Rezoning Transportation Analysis
Petition Number: Insert Zoning Petition #2020-195
General Location Identifier: Tax ID 21159315

| Revision Log: | Date | Description |
| | 01-21-21 | First Review (LJ) |

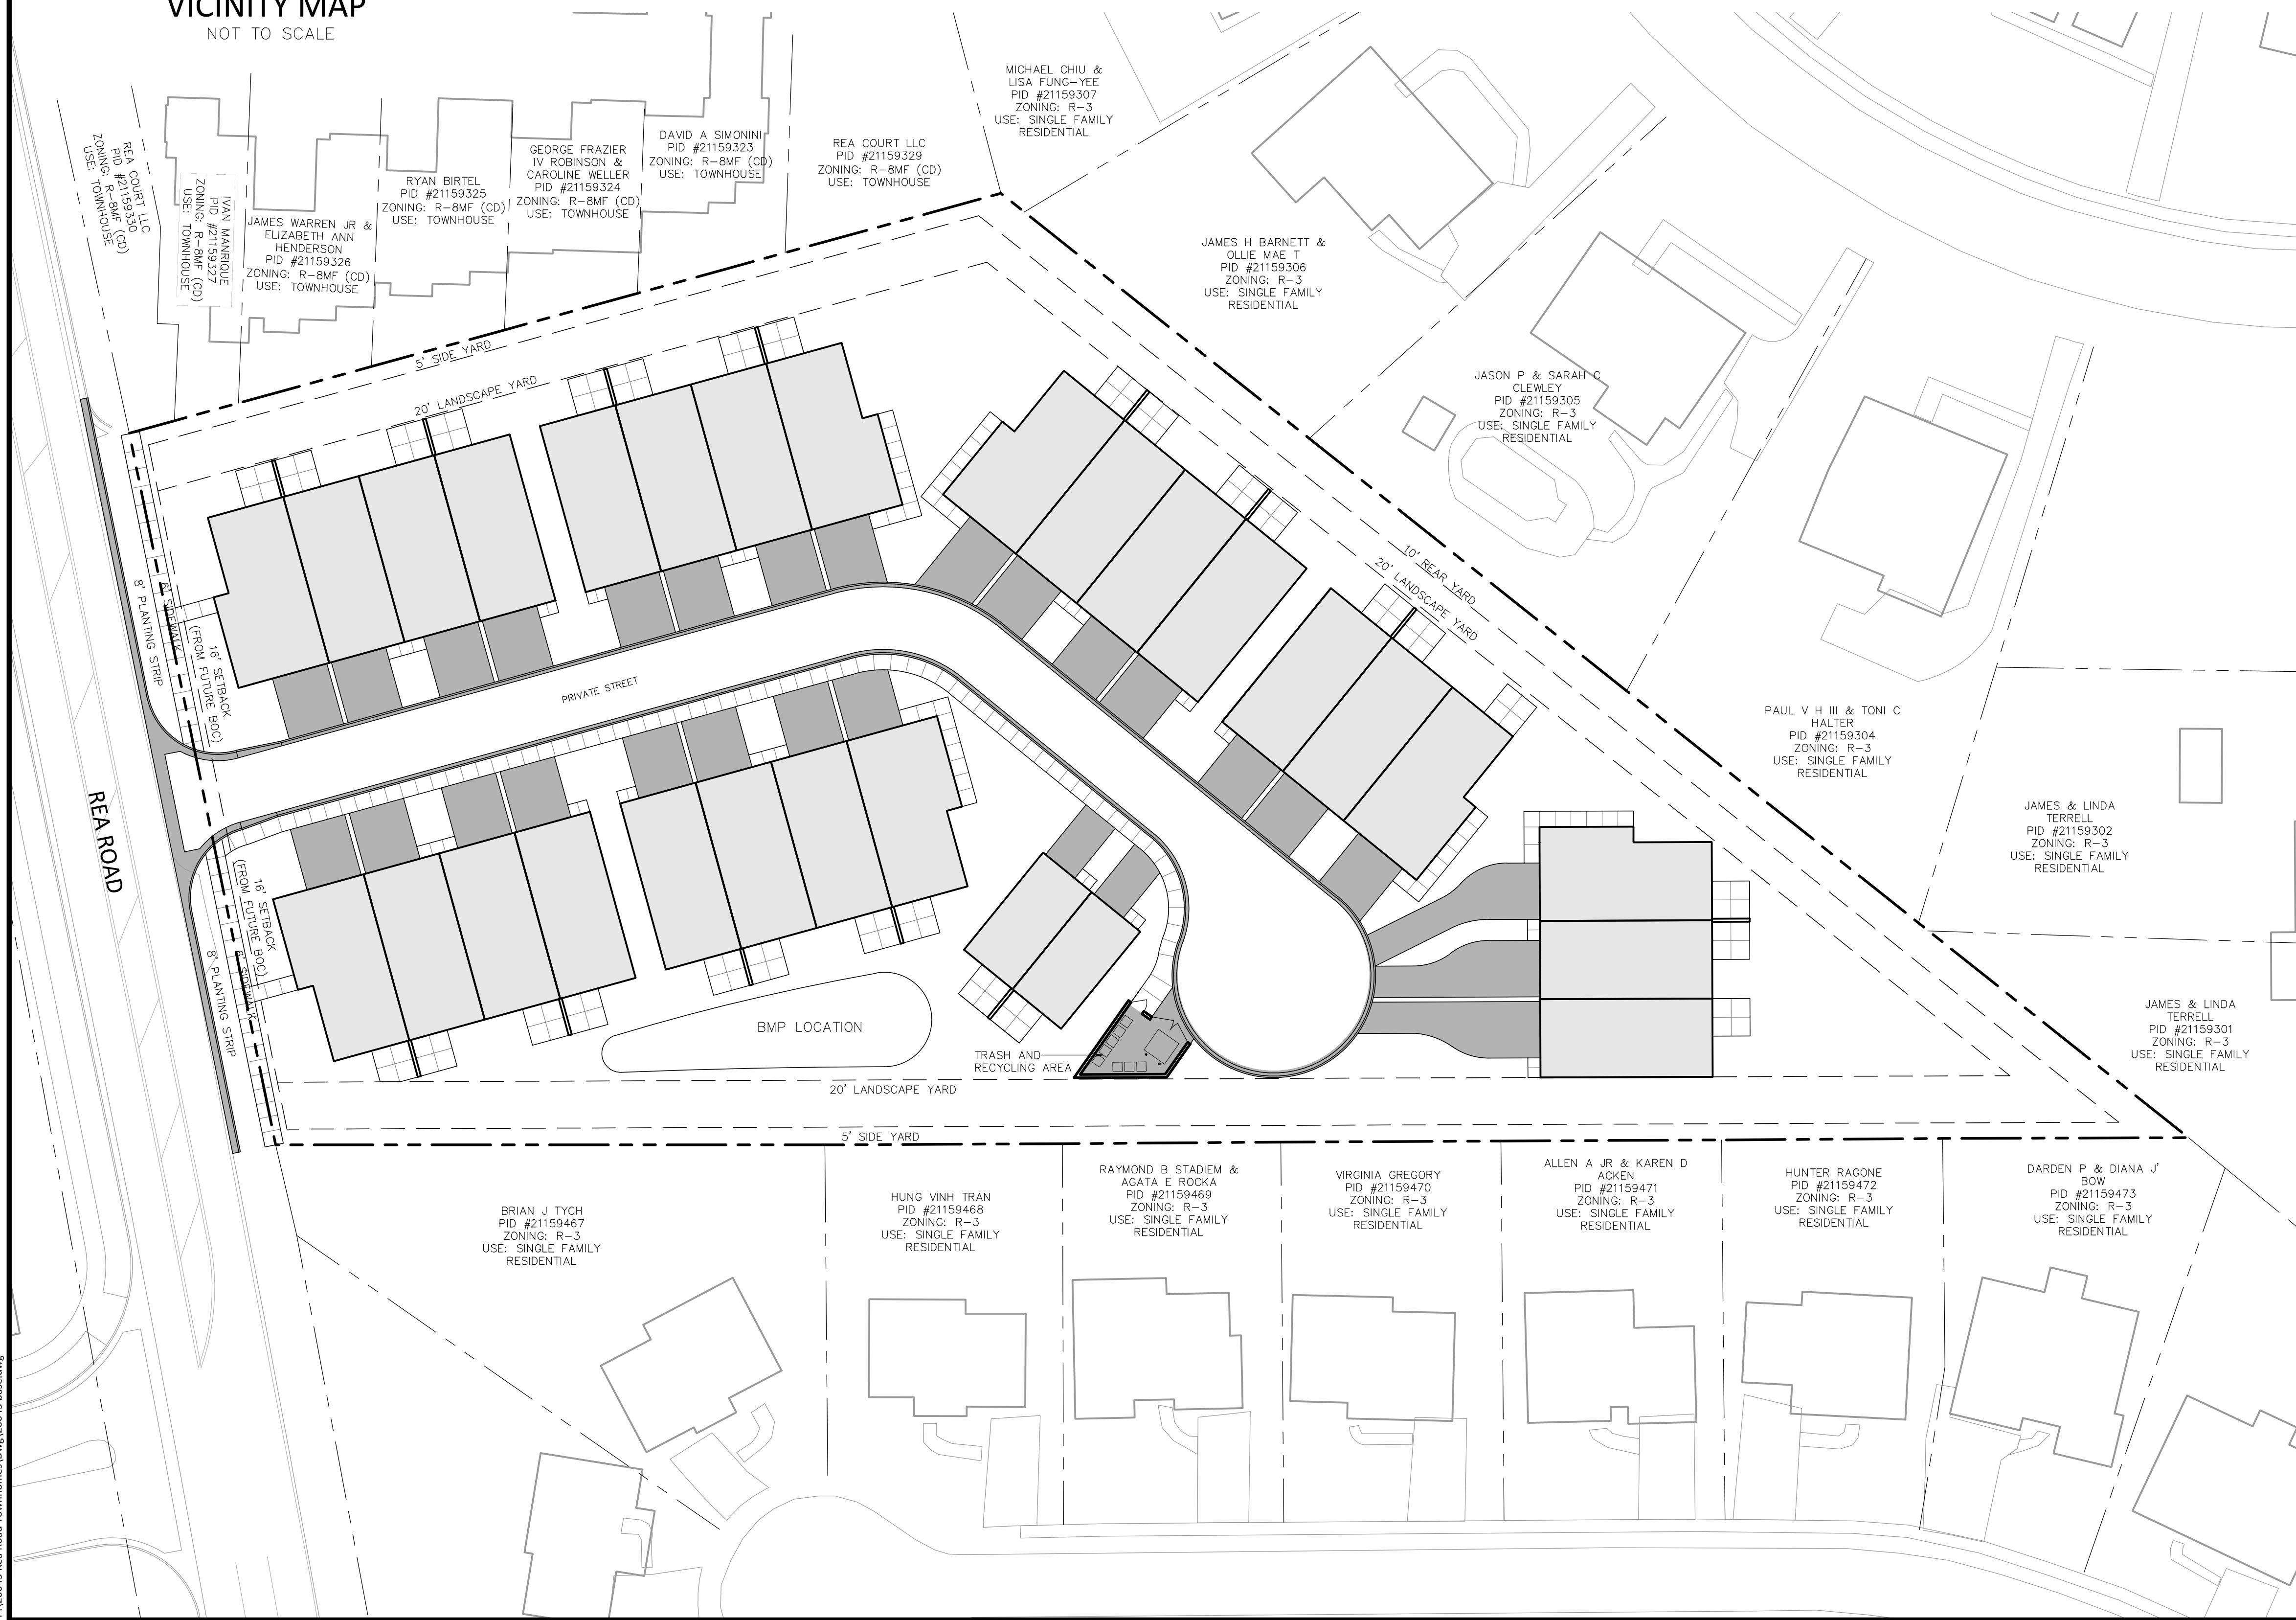
1. **Curblines:** The proposed zoning district has a setback measured from back of the existing curblines.
Rea Road (NCDOT): The future location of back of curb and gutter is 27' from the Rea Road centerline. Label and dimension the curb and gutter from the centerline for each road on the site plan.

3. Revise site plan and conditional note(s) to commit to dedicate 35' right-of-way from the road centerline. The site plan shall label and dimension the right-of-way from the road centerline.
4. Revise site plan and conditional note(s) to commit to construct an 8-foot planting strip, and 6-foot sidewalk on Rea Road per Chapter 19 / Chapter 20. The site plan shall label and dimension both items from the back of curb and gutter and road centerline.
5. Provide a left turn lane on Rea Road as required by NCDOT. Restripe Rea Road, per NCDOT Roadway Standard Drawing for PAVEMENT MARKINGS Turn Lanes, 1205.05, to accommodate the left turning lane to include storage.

- 6. Site plan and conditional note(s) revisions are needed to meet CLDSM standards. Provide a pedestrian refuge across Rea Road, per CLDSM, 11.41, complying with ADA/PROWAG standards. The pedestrian refuge also meets the Charlotte WALKS Policy.

- 7. Site plan and conditional note(s) revisions to label the private street as a CLDSM, 11.13 Private Street.
